PRE-HEARING STAFF ANALYSIS

Rezoning Petition No. 2008-081

Petitioner: Raley Miller Properties

Location: Approximately 9.26 acres located on the northeast corner of Ridge Road and Prosperity Church Road

ILLUSTRATIVE SITE PLAN
SCALE= 1:50

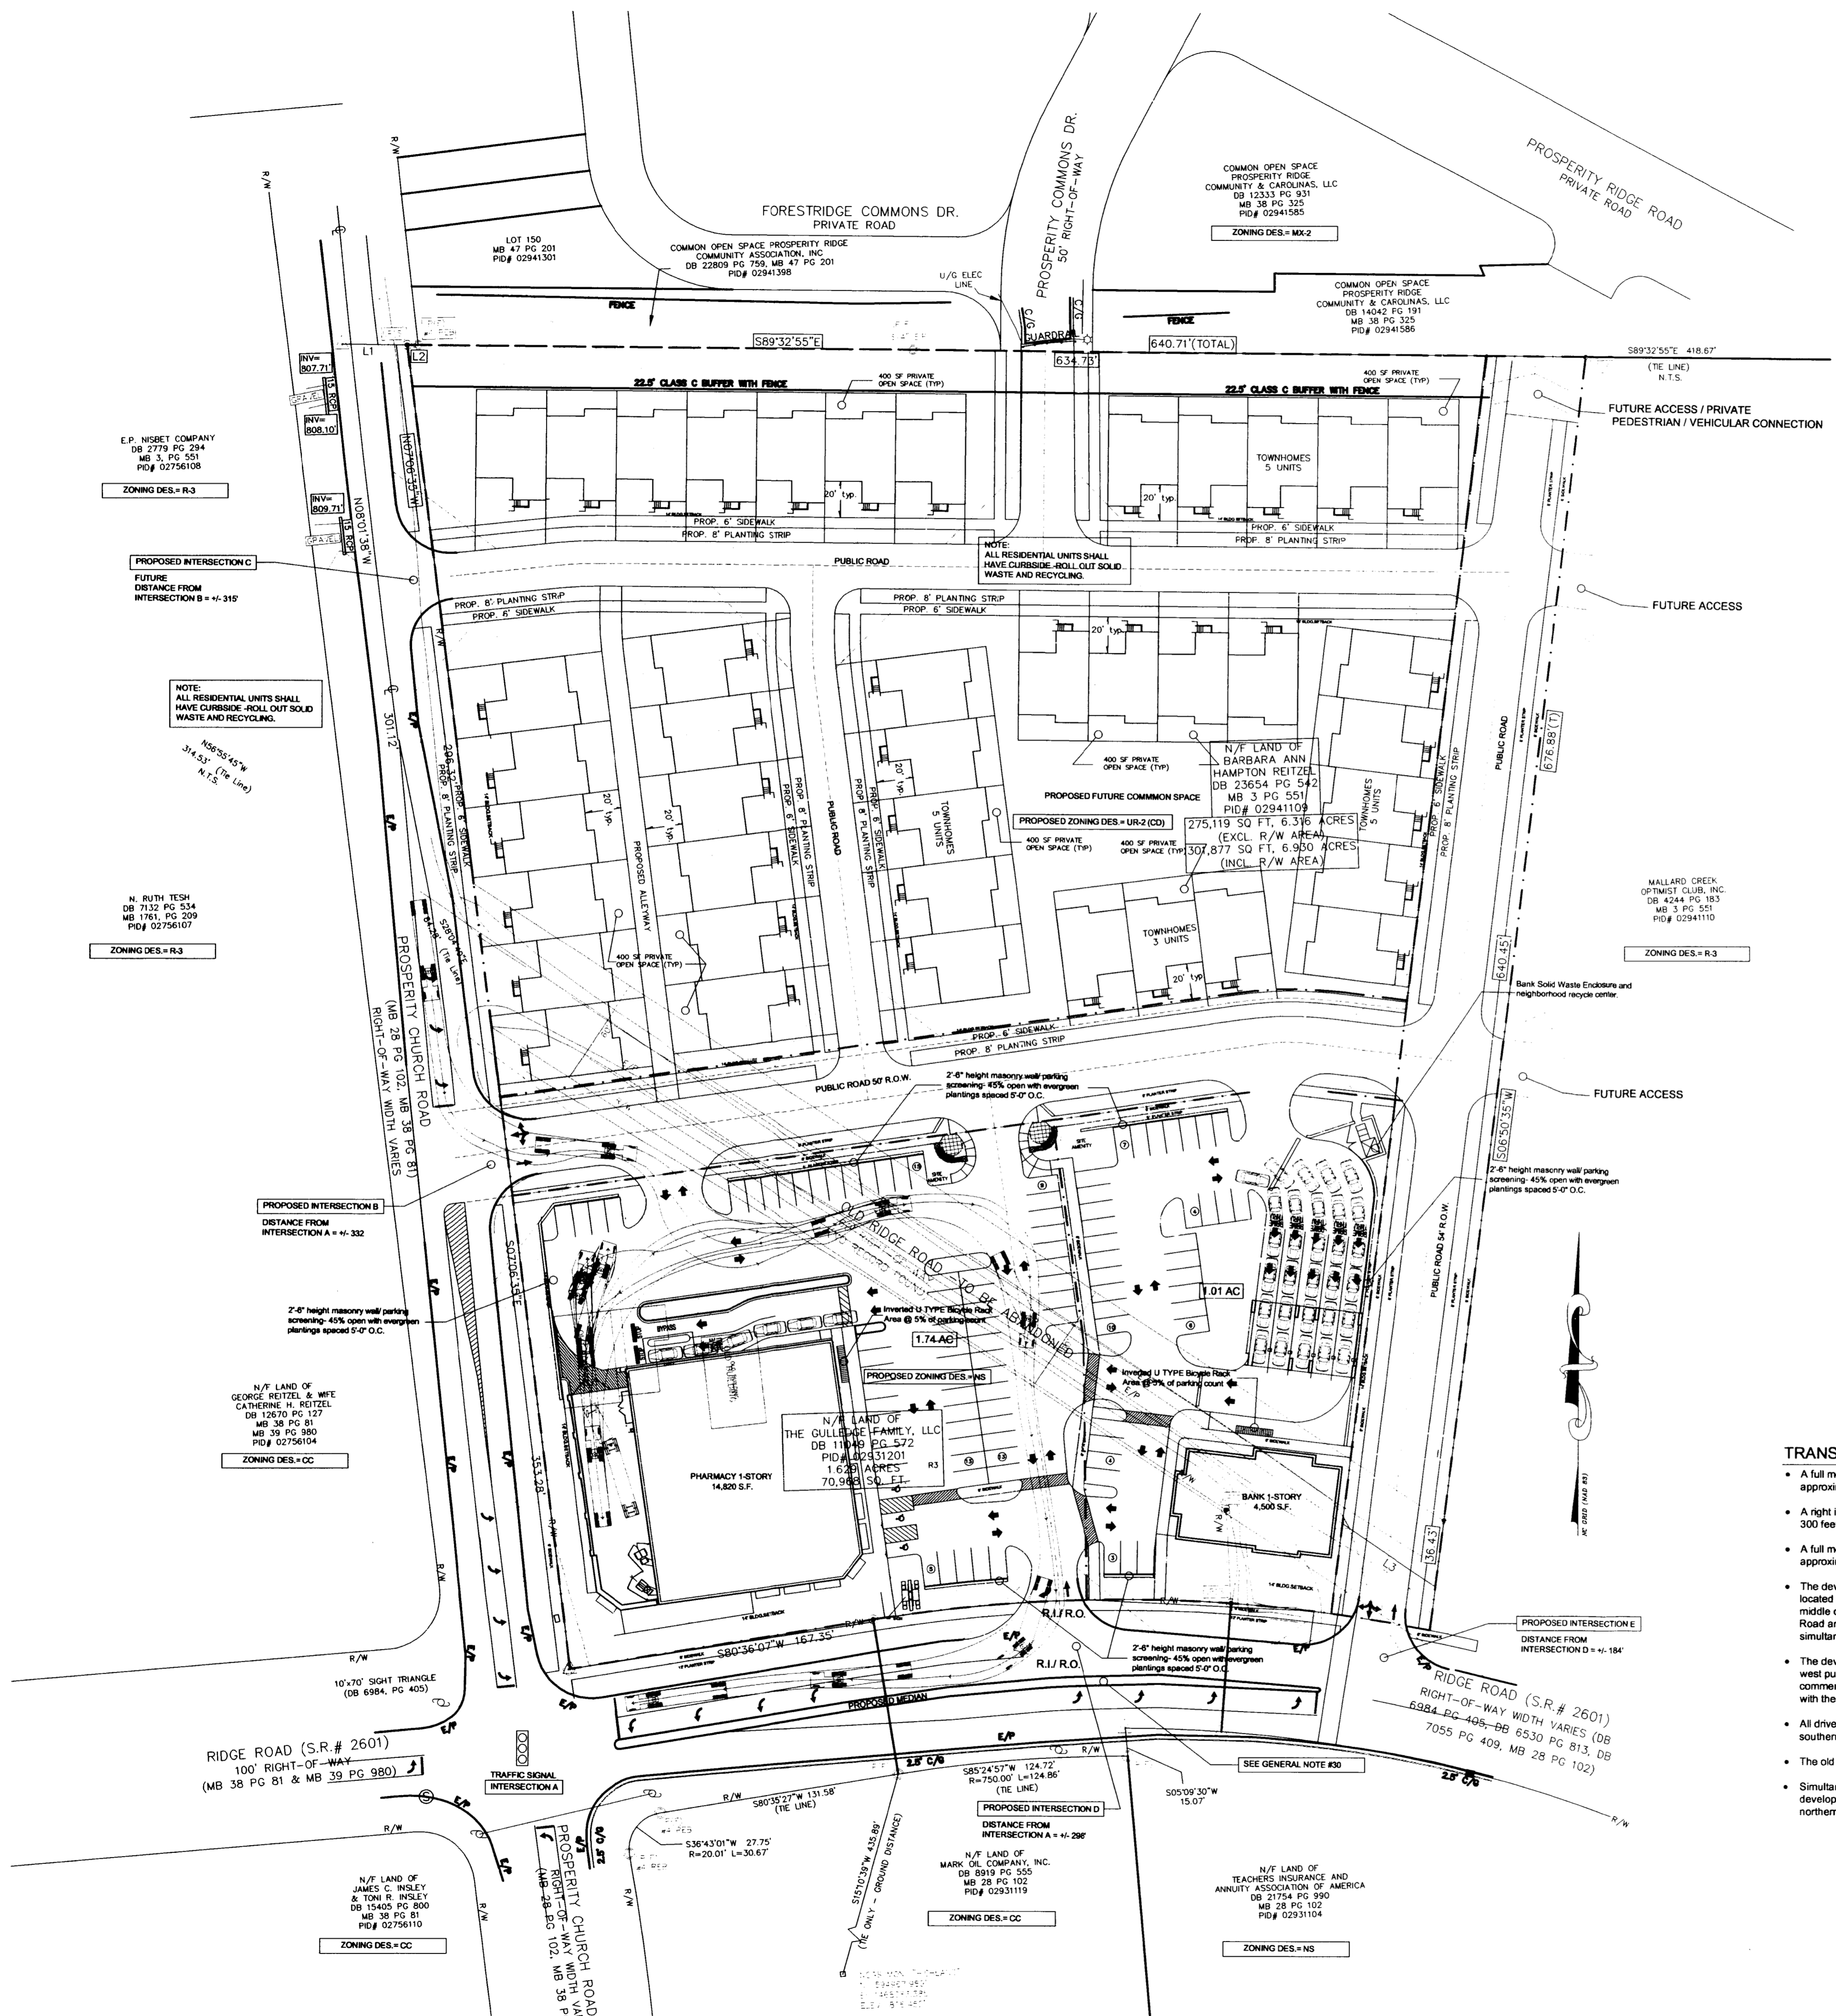
The petitioner should revise the site plan to identify *Rezoning Petition 2008-081*.

On the site plan under “Building Data”, the petitioner should note “Town Homes For Sale”.

The “Site Data” on the site plan indicates the front setback for a principle structure is 14 feet. The site plan should be revised to indicate the 20-foot setback required for garages. Staff has concerns that some of the units as shown on the site plan do not meet this requirement.

The petitioner should clearly show on the site plan the minimum required street setback in the UR-2(CD) and NS zoning districts. Be aware that stairways cannot encroach into this setback and doorways cannot open into the required setback.

The petitioner should revise the site plan to provide and clearly label required sidewalks and planting strips along all public streets, and along Ridge and Prosperity Church Roads. All internal sidewalks should connect to all public streets. In addition, the petitioner should provide and show crosswalks on the site plan.

The petitioner should revise the site plan and place the street trees in the planting strips along Ridge and Prosperity Church Roads.

The petitioner should revise the site plan to show the requested Class “C” buffer along the portion of the subject property abutting R-3.

The parking located along the entrance way on Ridge Road should be removed and the area redesigned to provide more of a “main street” with sidewalks and planting areas. Sidewalks should connect to Ridge Road sidewalk, including a pedestrian connection between the proposed southernmost east/west public street and Ridge Road.

The petitioner should revise the site plan and extend walkways adjacent to the bank and pharmacy to the sidewalk along Ridge Road.

Some of the proposed parking spaces facing Ridge Road encroach into the established setback. The petitioner should revise the site plan to either move the buildings closer to the street, or to remove those parking spaces.

The petitioner should show and indicate percentage of tree save area on the site plan.

The petitioner should show site triangles on the site plan.

The petitioner should revise the site plan to depict location and number of bicycle parking spaces in accordance with off street parking standards.

The petitioner should revise the site plan to show the locations of the solid waste/recycling area for the proposed bank and multi-family development.

Parking lots must be screened from all public rights-of-way. In order to enhance the appearance and improve the appearance of the parking areas, staff requests a 2.5-3' high finished masonry wall which is 40-50% open for security purposes and a minimum three foot wide planting strip for small evergreen shrubs 5' on center.

The petitioner should provide pedestrian scale lighting throughout the development, and locations should be shown on the site plan.
